From: Anita Gardner
Sent: 30 January 2019 16:41
To: Karen Parsons
Subject: FW: K/40/18/PL - Demolition of existing dwelling & erection of 1 No. dwelling, associated landscaping & parking (resubmission following K/11/16/PL)

I have started looking through your application and considering the representations made. I note that there is a comment that "The planning application includes a new cross over on the verge which is owned by Kingston Gorse Estate therefore Certificate B should have been completed and Notice no 1 served on the Estate."

I recall this was also an issue on the previously approved scheme. Accordingly you will need to amend the application form with Certificate B completed and revise the red edged site area to include the access. I will also require an issue index sheet to ensure that all amendments are properly recorded.

Drawing: Proposed Garage Elevations
Dwg No: 247-D-15

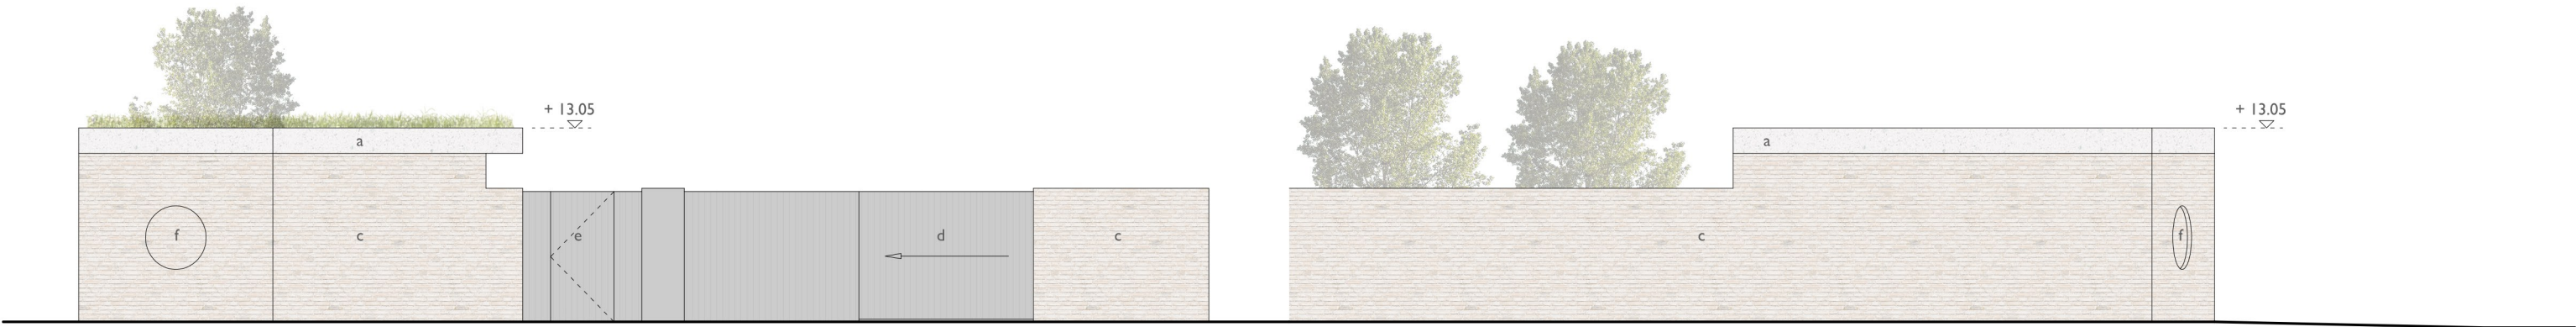
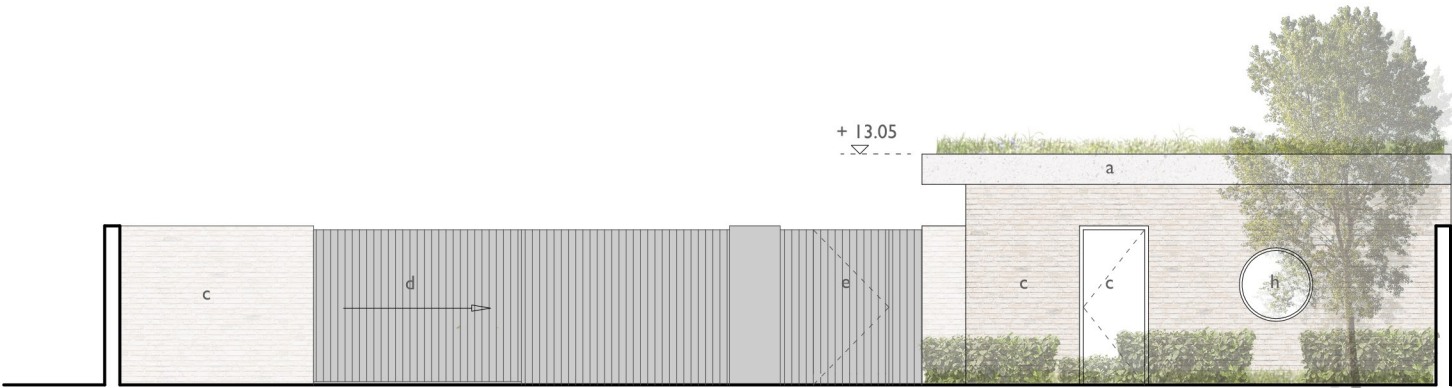
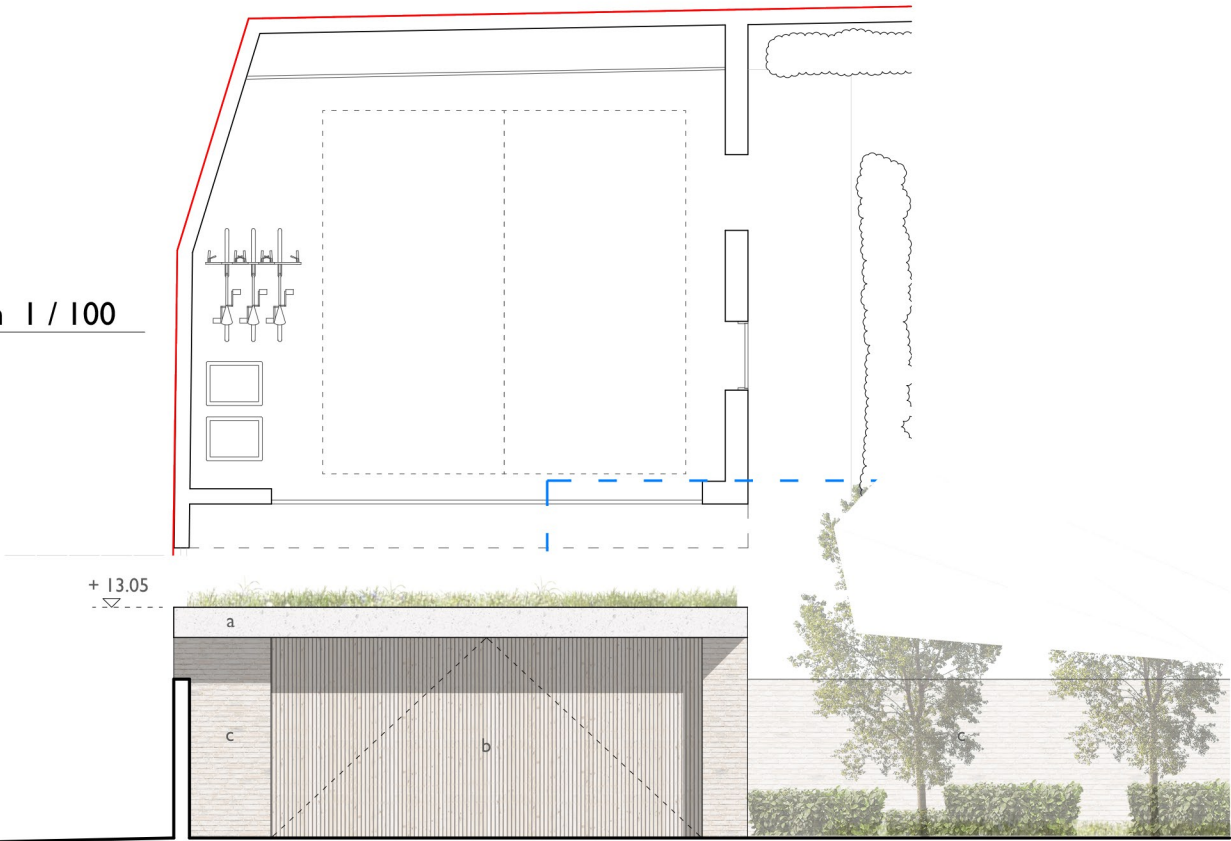
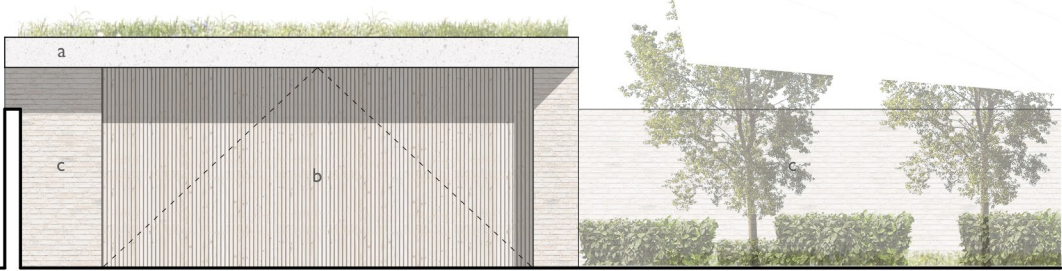
I will substitute these plans for the originals. Please can you also confirm that drawing 247-D-15 is to be deleted from the application and provide a new plans index sheet

The Board have requested that we remove the detached garage to the front of the plot and that we make the North facing window to the 2nd floor obscured.

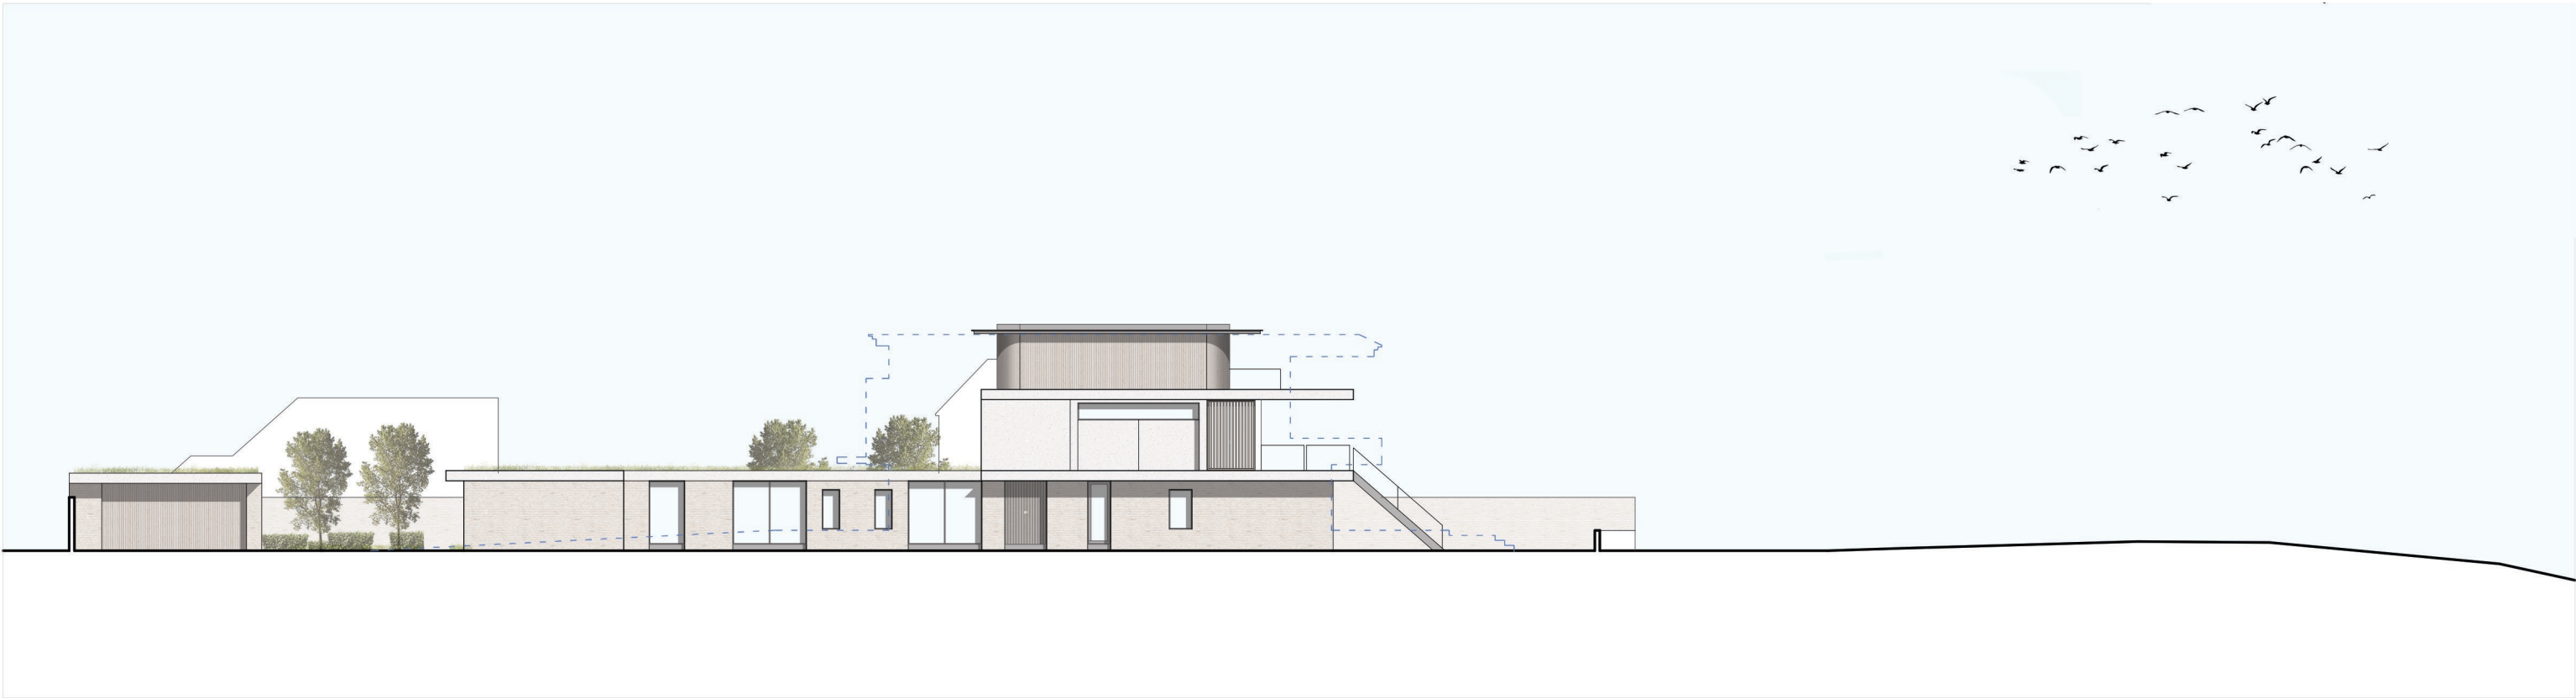
The proposal is only ever so slightly higher than the existing house and just marginally higher (100mm) than the 2018 permission for a new dwelling but it is significantly less impactful than the 2018 permission because of the shallow depth of the upper storeys (see attached application drawing D-17). This means that the impact of the proposal on the garden of *Mariners* will be very limited, in particular when compared to the extant permission. Indeed because of the siting of the main part of the building over the footprint of the existing house, there will be very little change from any shadowing that occurs at present.

Obscure glazing to 2nd atrium window

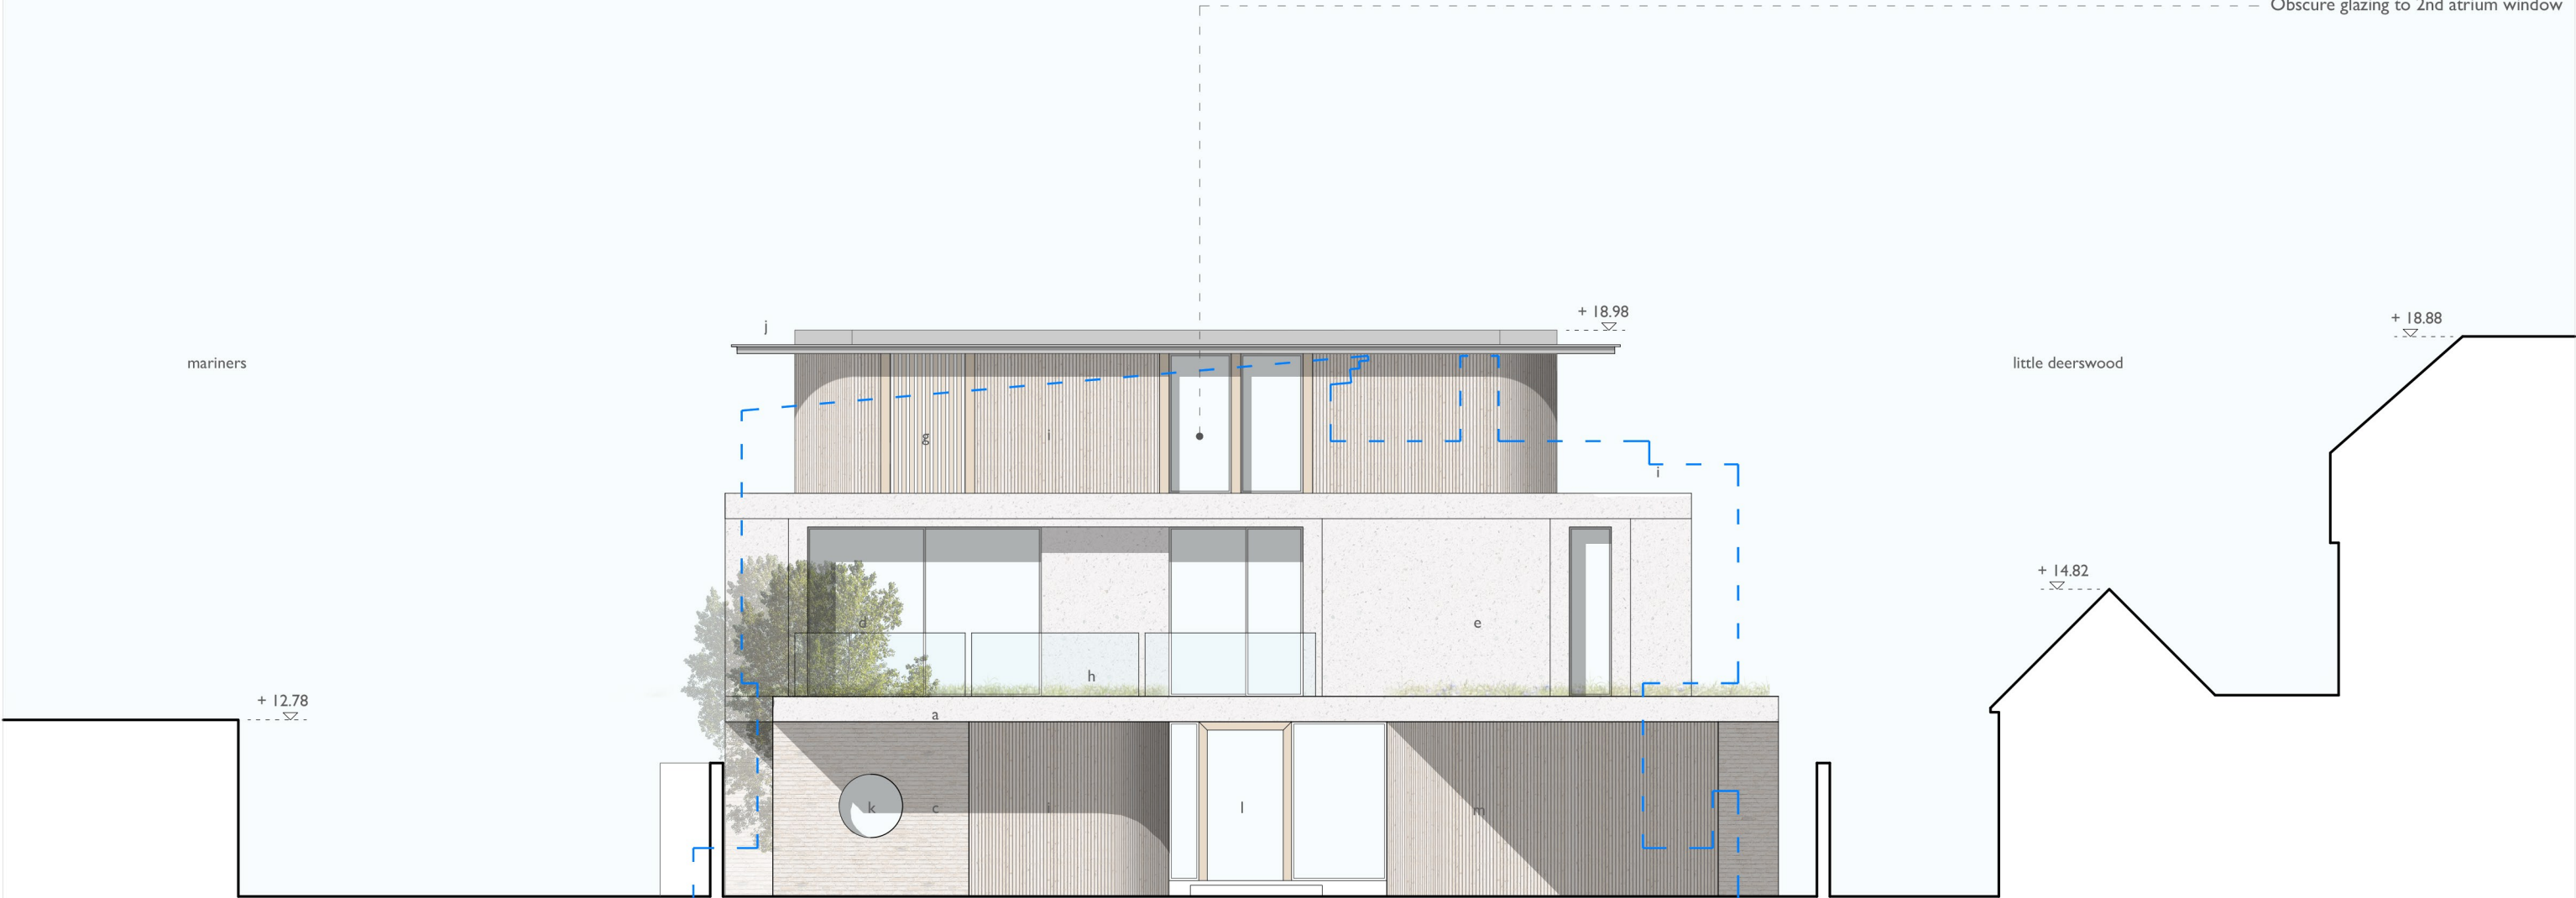
The window at 2nd floor looking to the North over Gorse Avenue is set a full 30m away from the property *Westwood*, and as we discussed on site, the views out from this window are limited as it opens out from an atrium space. However should there be a concern with the impact of this window on the houses to the North, we would be pleased to propose this as obscure glazing.
